Hansen Yuncken
Sydney Corporate Park
Building 1, L3, 75-85 O'Riordan Street
Alexandria NSW 2015

RE: Murrumbateman Public School SSD RFI

Reference is made to the response to submissions from Yass Valley Council, Transport for NSW (TfNWS) and NSW Department of Planning, Industry and Environment (DPIE) with respect to SSDA submission for the new school in Murrumbateman (Reference SSD – 11233241). Our responses to the submissions are provided in the table below.

DRAWING NAME  
**LANDSCAPE: SITE FINISHES PLAN**

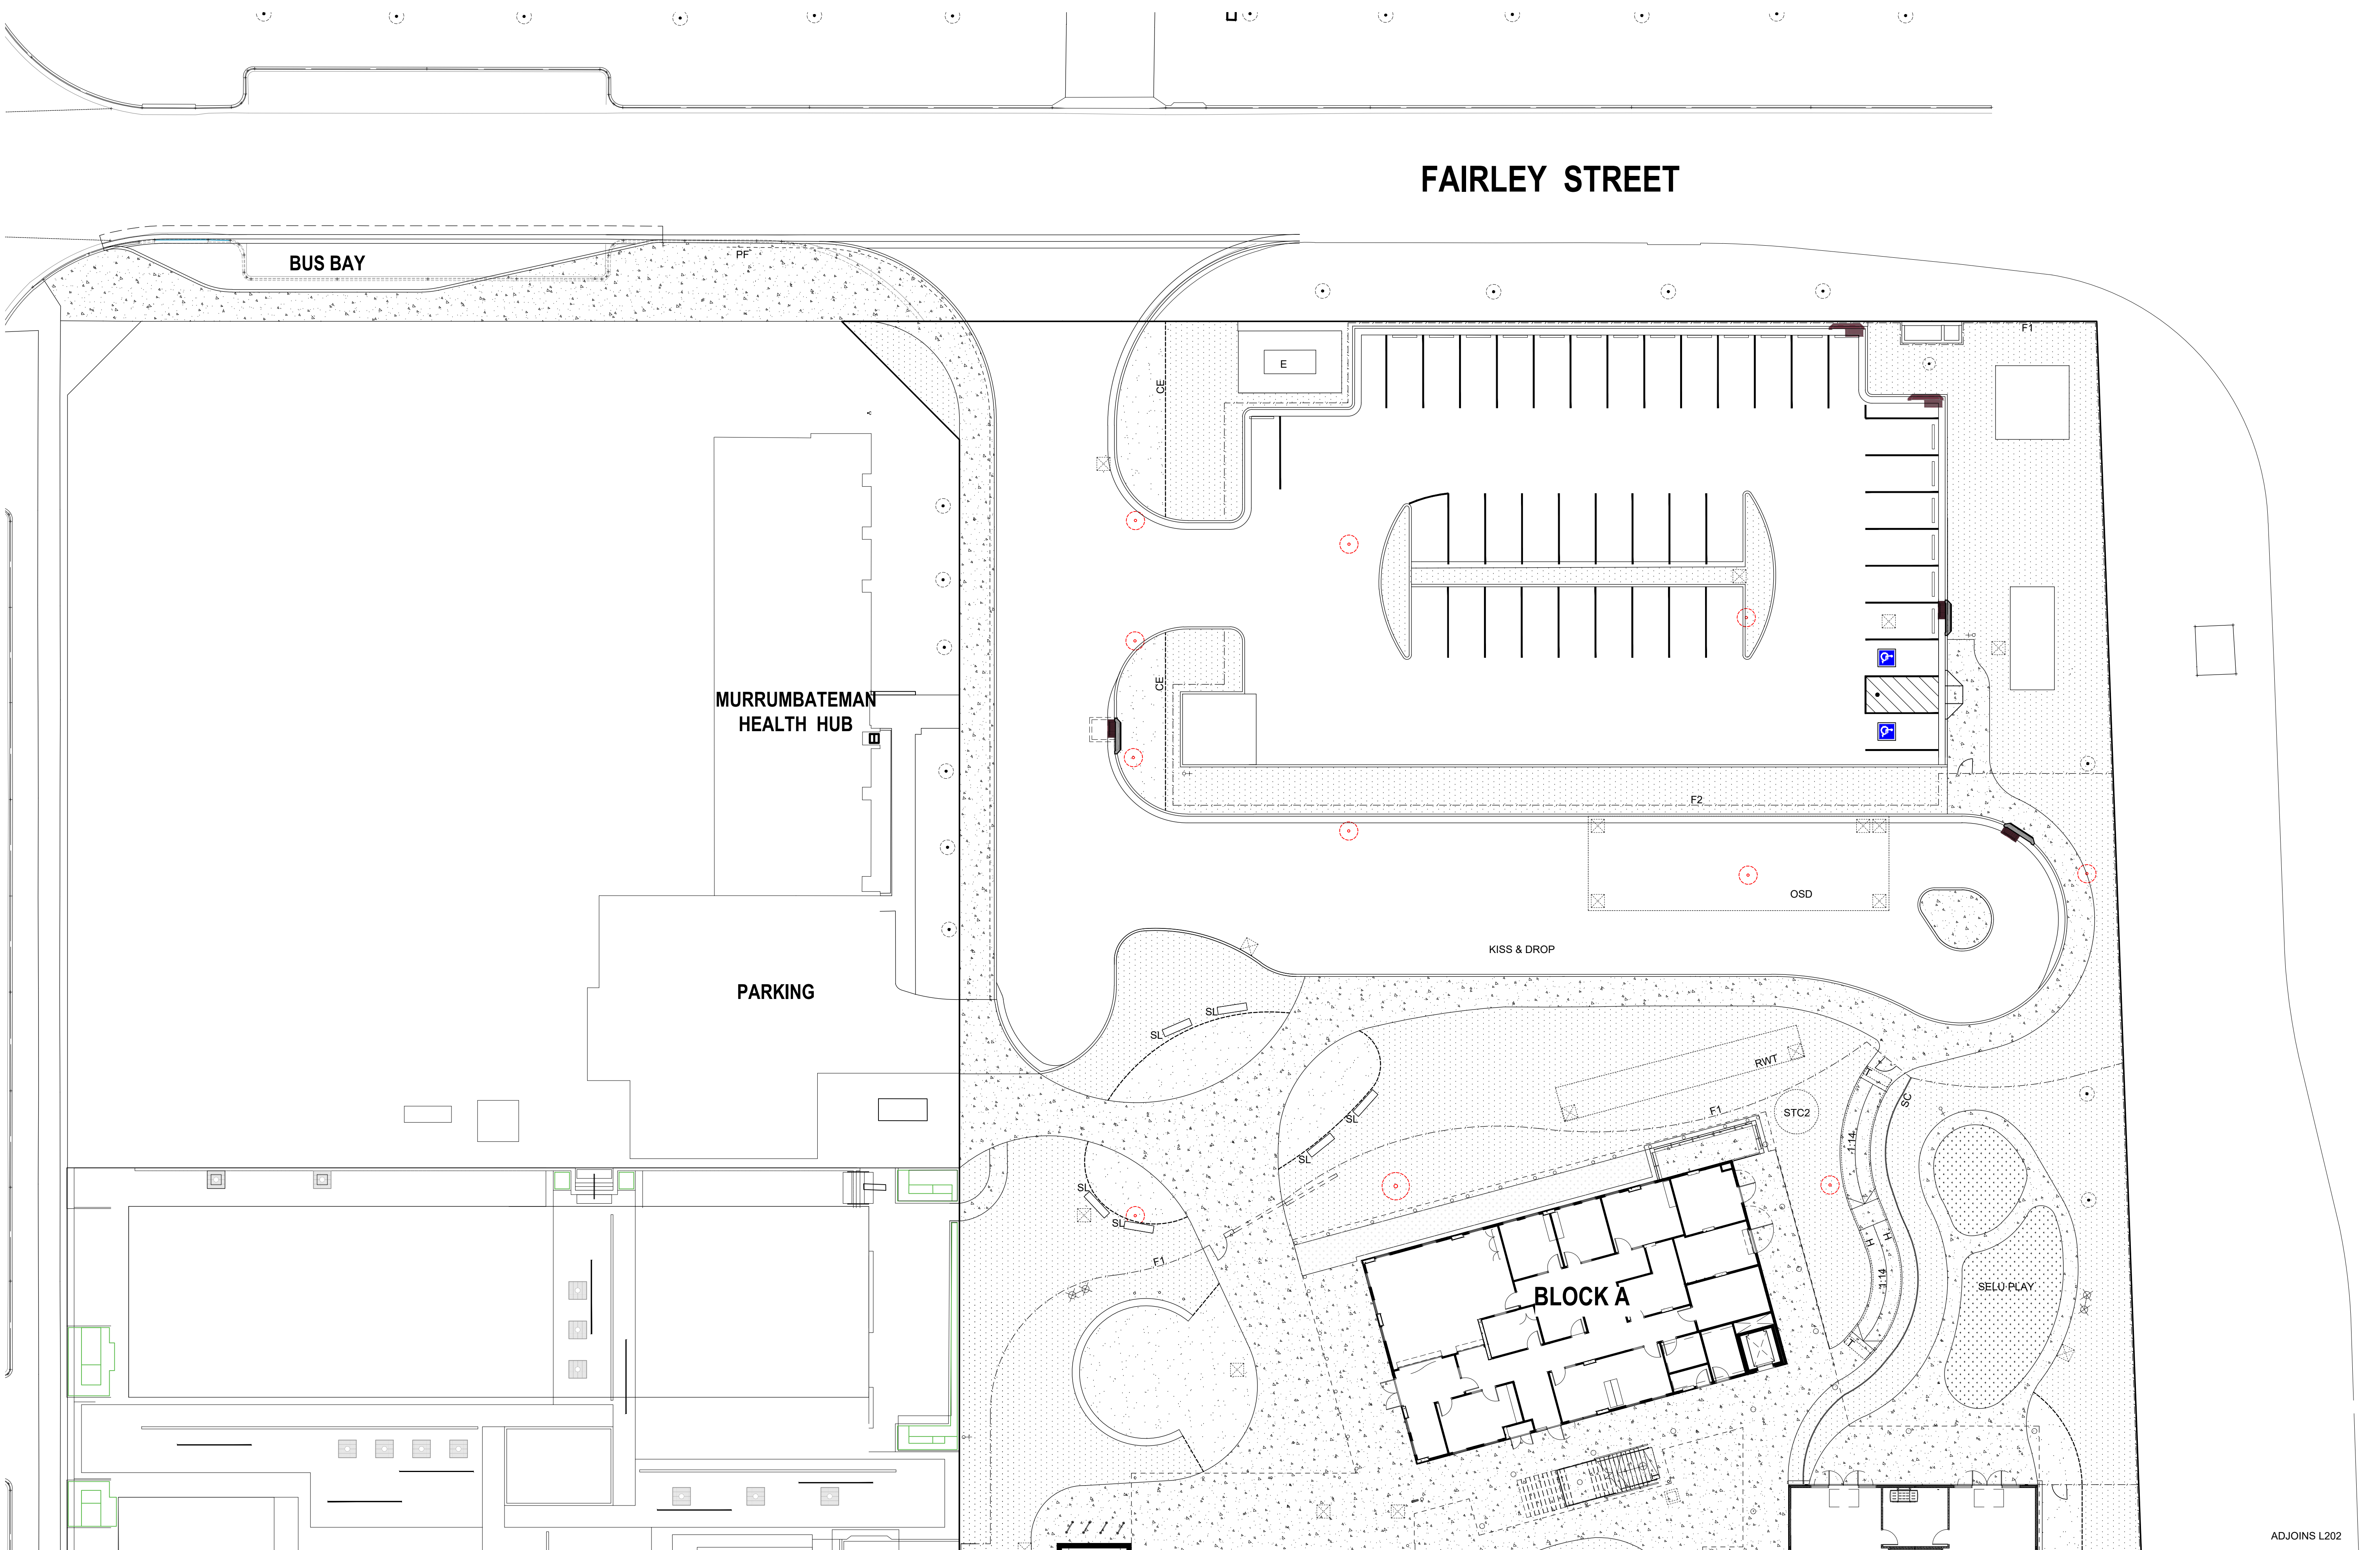
Further to the comments below, DPIE have queried the width of the footpath leading to/from the Bus Bay along Fairley Street and the overall pedestrian management in the area. Austroads Guide to Road Design Part 6A: Paths for Walking and Cycling provides guidance on the suggested width requirements for pedestrian footpaths. It states that the clear footpath widths are dependent on the following factors:

The submitted plans showed a pedestrian footpath leading to/from the proposed bus bay on Fairley Street with a clear width of 2.5m.

A fence has since been proposed to be installed along the length of the pedestrian footpath leading to/from the proposed bus bay on Fairley Street to the school. The fencing installation will reduce the clear width of the footpath to 2.3m.

The reduced footpath width is wider than the required minimum for wheelchair users to pass and marginally below the suggested minimum of 2.4m which allows for high pedestrian volumes, as stipulated in Table 5.1: Width Requirements for pedestrian paths of Austroads Guide to Road Design Part 6A: Paths for Walking and Cycling.

Given that the majority of cyclists will be utilising the southern entrance and that the proposal provides at least two entrances to/from the school, the reduction in width is not expected to significantly impact on the pedestrian usage of the footpath.

As such, the width of the pedestrian path is sufficient to cater for the anticipated pedestrian movements associated with the proposed new school in Murrumbateman.
